2024/0694

Police Station House, Wood Walk, Platts Common, Barnsley, S74 9SH

**Remove existing conservatory and erection of first floor side extension with rear facing balcony, new car port and single storey rear extension, entrance lobby and relocation of fence and gates.**

Drawing Title  
**PROPOSED EXTERNAL  
ELEVATIONS**

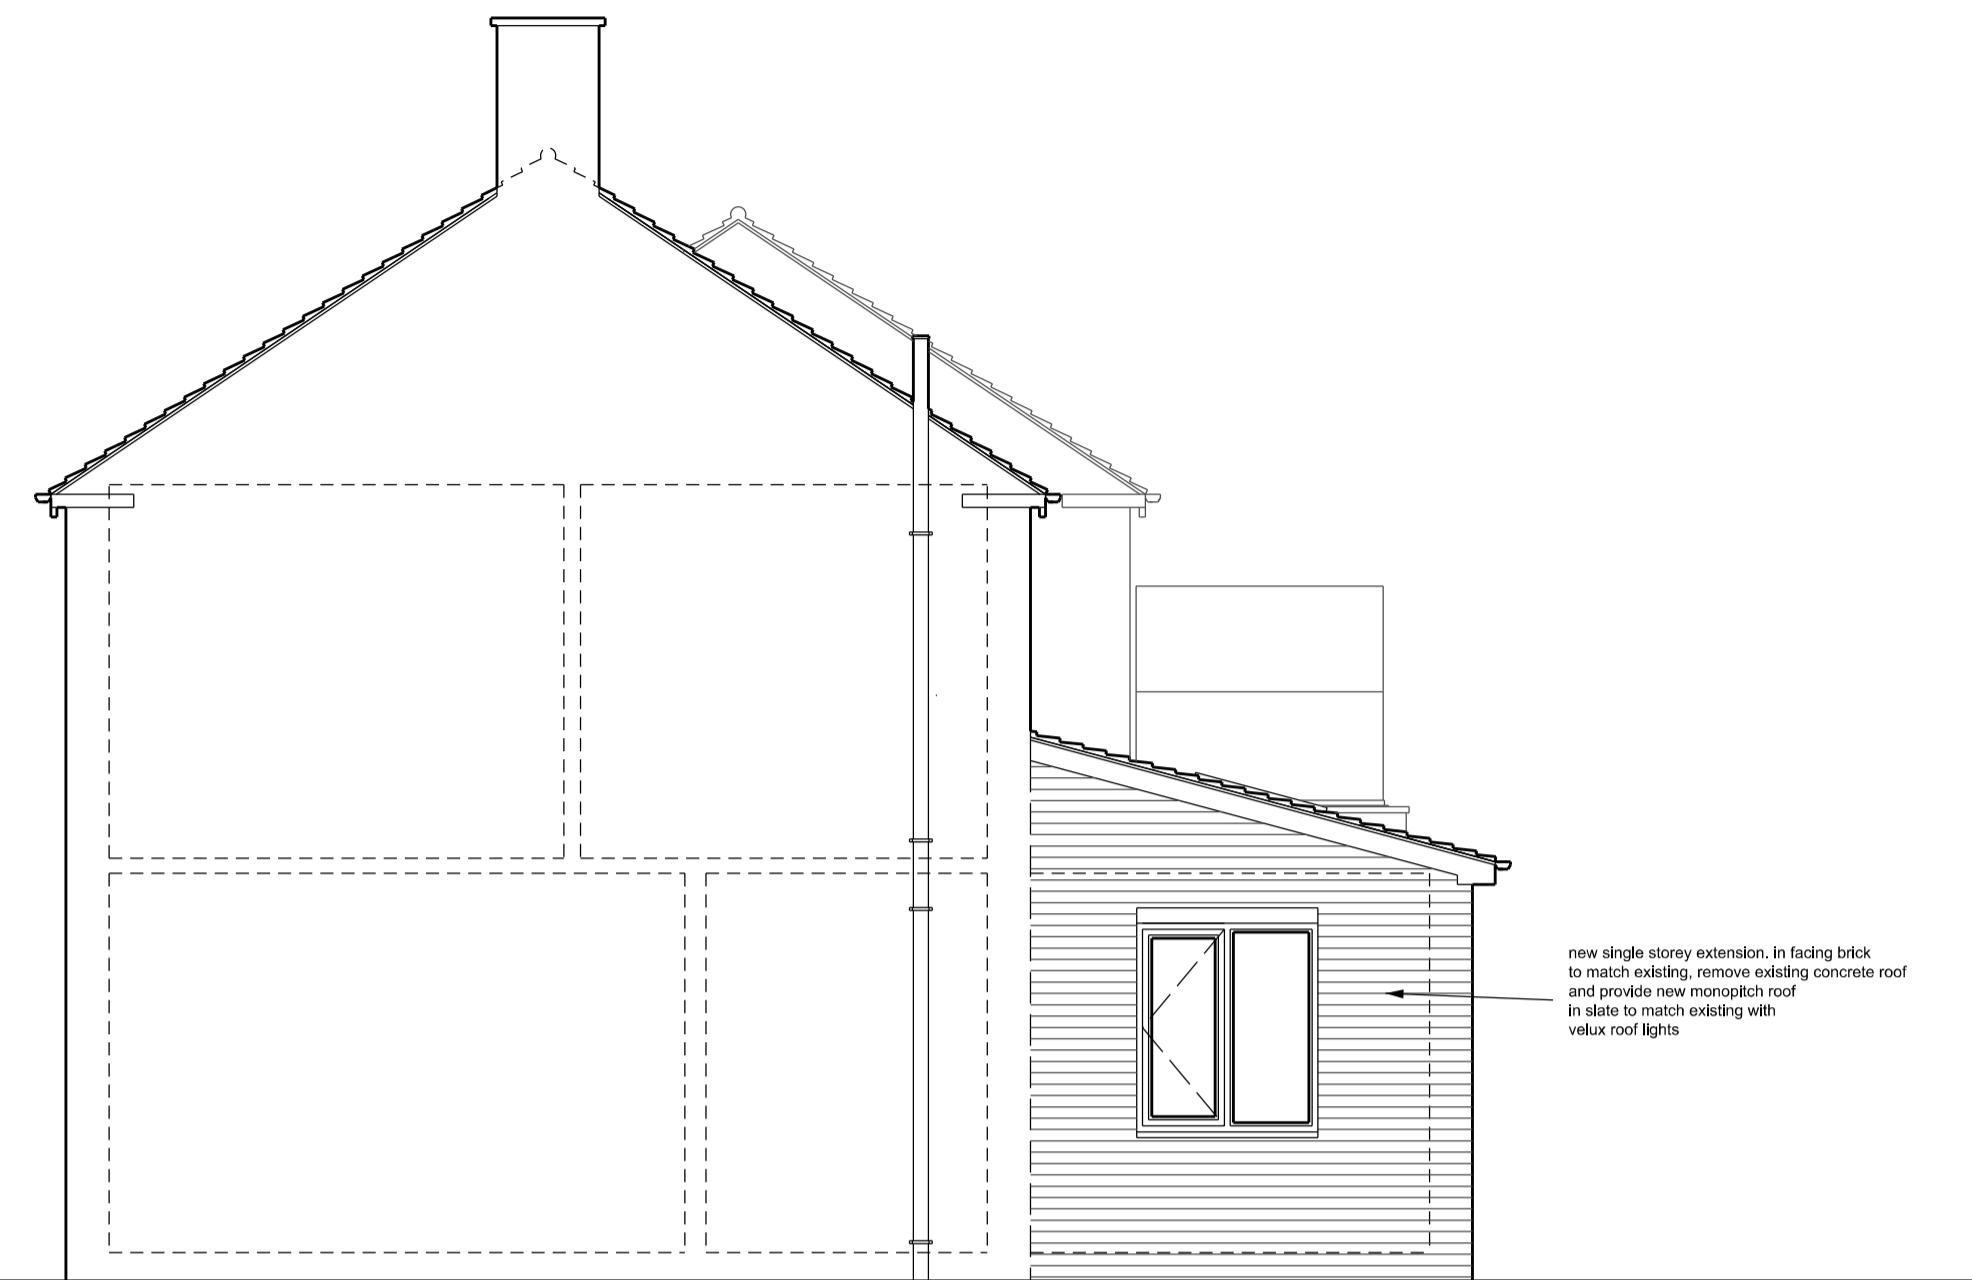
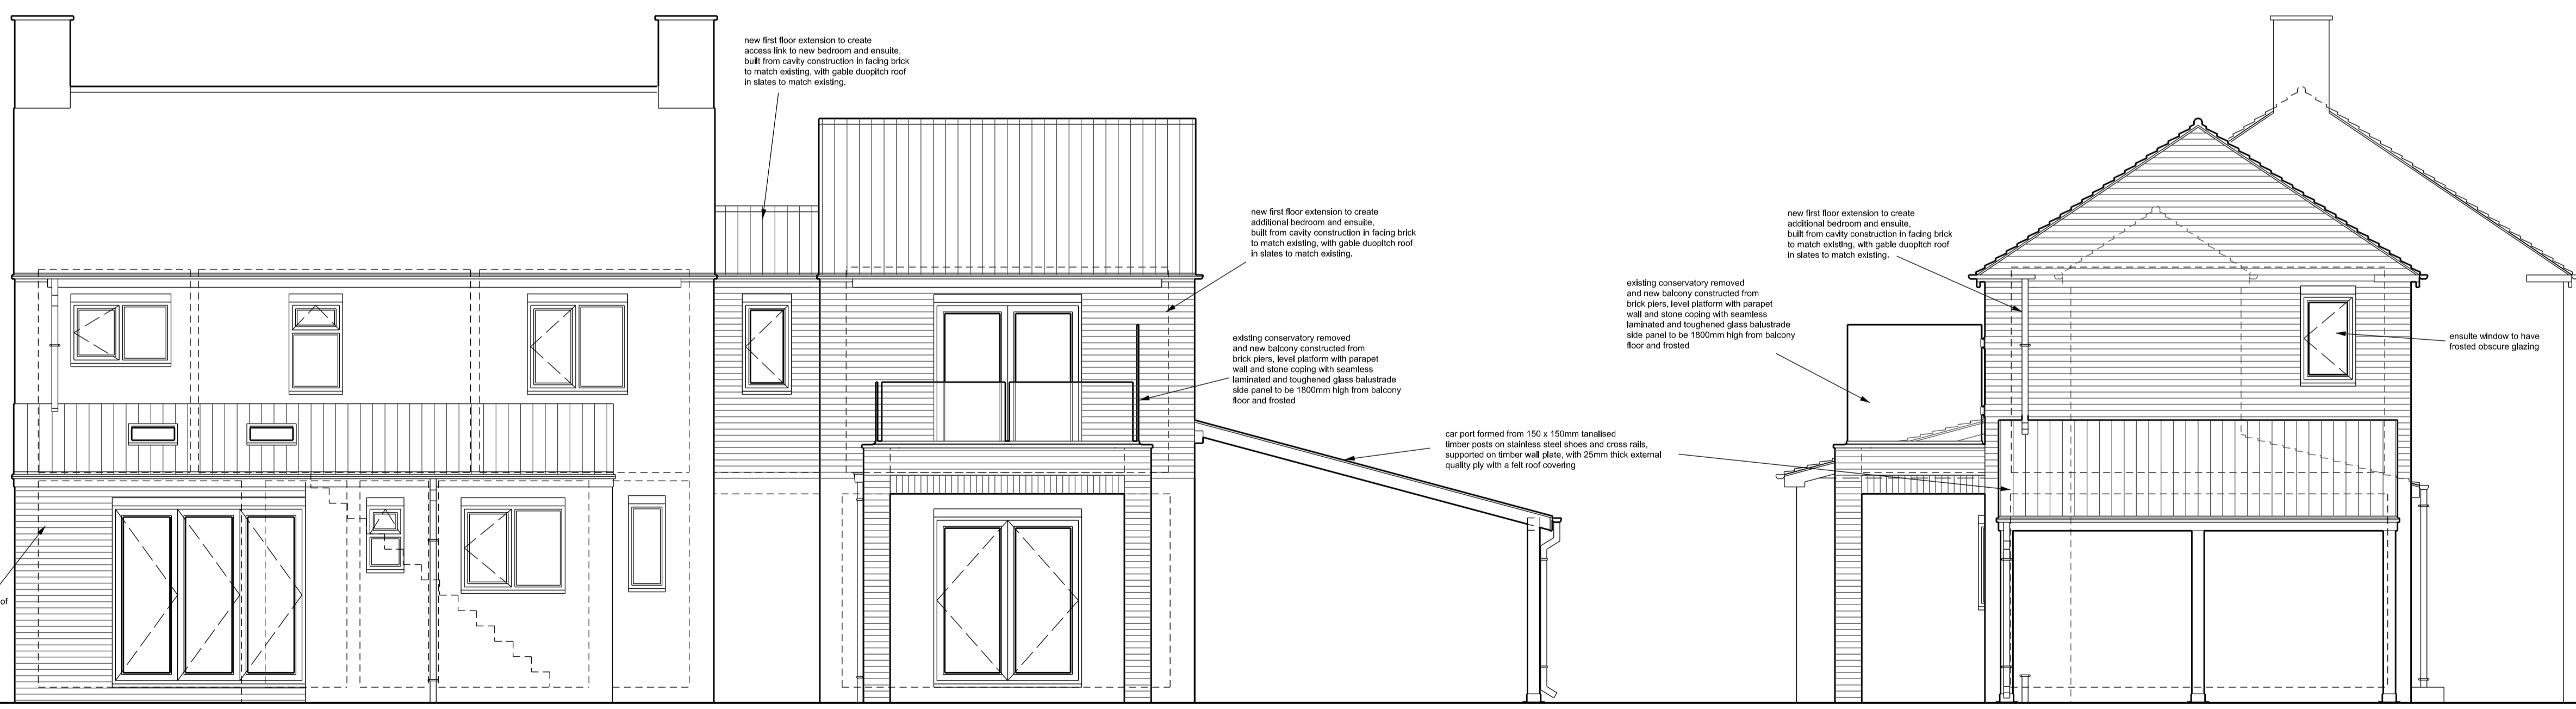
During the application process, the proposal was amended to alleviate concerns in relation to visual amenity, mainly in that the roof did not reflect the style of the existing roof or the roofs of surrounding properties, and that the windows did not reflect the size and positioning of the existing windows.

The proposed first floor extension would adopt a modest scale following the footprint of the existing side projection. The extension would adopt a new pitched roof and would be linked to the main dwelling with a smaller first floor extension with a pitched roof. New windows would repeat the proportion and style of and would line through with existing windows. These are welcome design choices that would vastly improve the appearance of the extension and the application property as a whole. The proposal would better reflect and harmonize with the design of the main dwelling and the character of the street scene.

The proposed rear extension would adopt a modest scale essentially acting as an infill between the main dwelling and the existing rear projection. The extension would adopt a new mono pitched roof. This is a welcome design choice that would greatly improve the appearance of the extension and would better reflect and harmonize with the design of the main dwelling.

The proposal is therefore unlikely to result in increased overlooking and would be acceptable in either instance. In addition, the proposed balcony is shown to incorporate a 1.8-metre-high privacy screen and the proposed first floor window facing towards the rear curtilage 84 Wombwell Road is shown to be obscure glazed.
